MEMO

Ref: 43721/APP/2026/871

Address: 13 CLAMMAS WAY, UXBRIDGE

Proposal: Subdivision of property into a 2-bedroom dwelling and a 3-bed dwelling, with associated amenity space, refuse and cycle parking. Erection of a part single storey, part two storey extension to the side and rear, conversion of roof space to habitable use to include a rear dormer and 2 roof lights.

01 -PROPOSED SITE PLAN
SCALE- 1:100

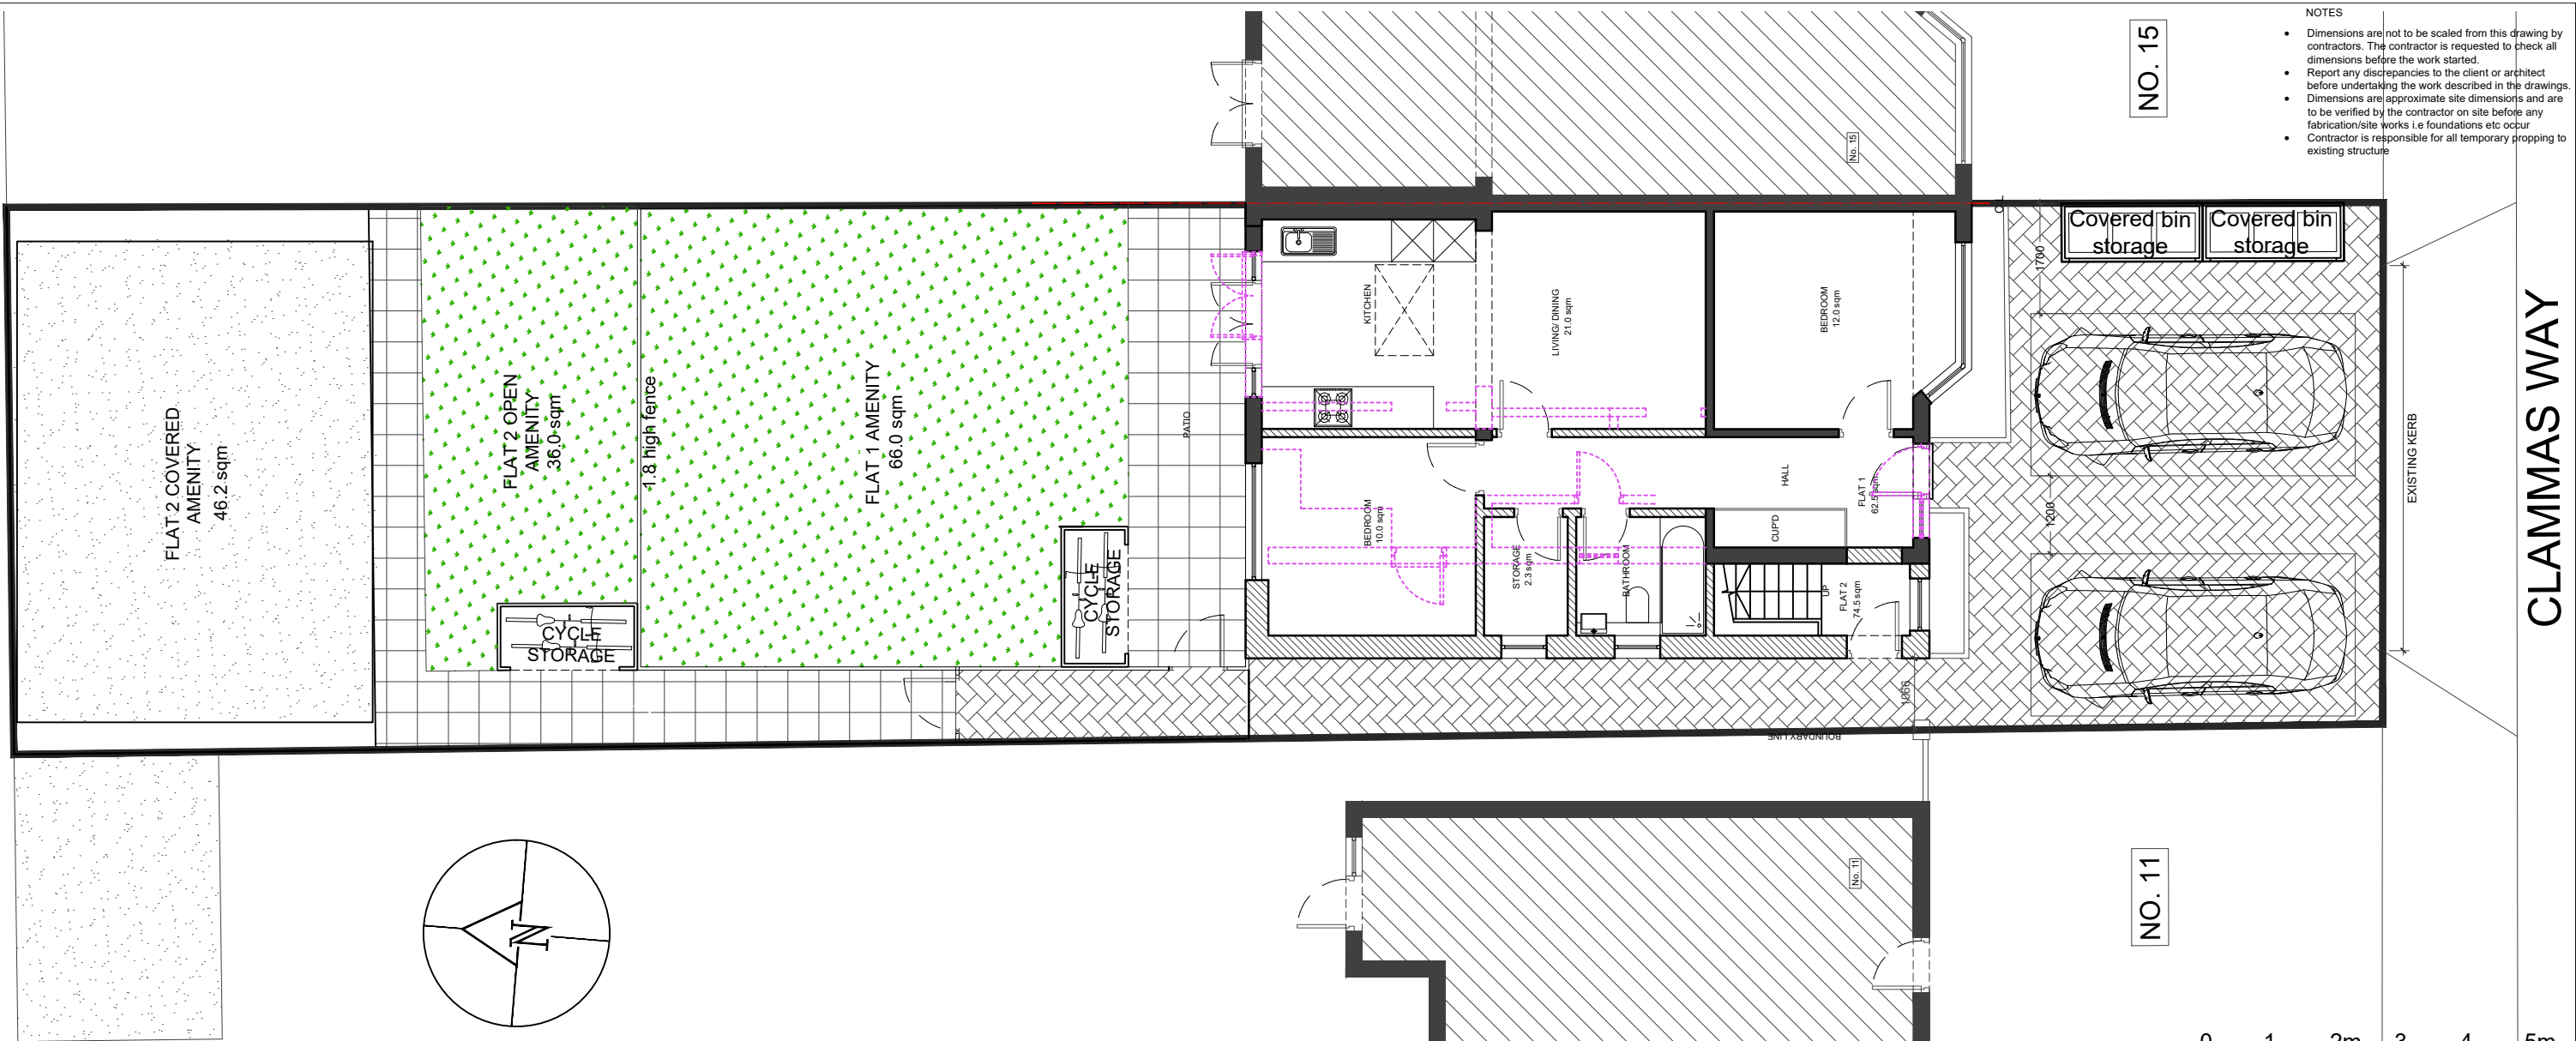
The applicant's claim of 3 existing spaces is not accepted, as:

- The third space would obstruct pedestrian and cycle access
- This would result in a substandard and unsafe arrangement

- Access is via a 1.07m wide side passage
- The London Cycle Design Standards (LCDS) require a minimum access width of 1.2m

- The arrangement is not compliant with the London Cycle Design Standards
- The applicant must review and revise the cycle storage and access arrangements to ensure policy compliance and adequate usability

No development shall commence until revised details of the cycle parking location have been submitted to and approved in writing by the Local Planning Authority, in consultation with the Highway Authority.

The details shall demonstrate that the cycle storage and access arrangements are fully compliant with the London Cycle Design Standards, including provision of a minimum access width of 1.2m.
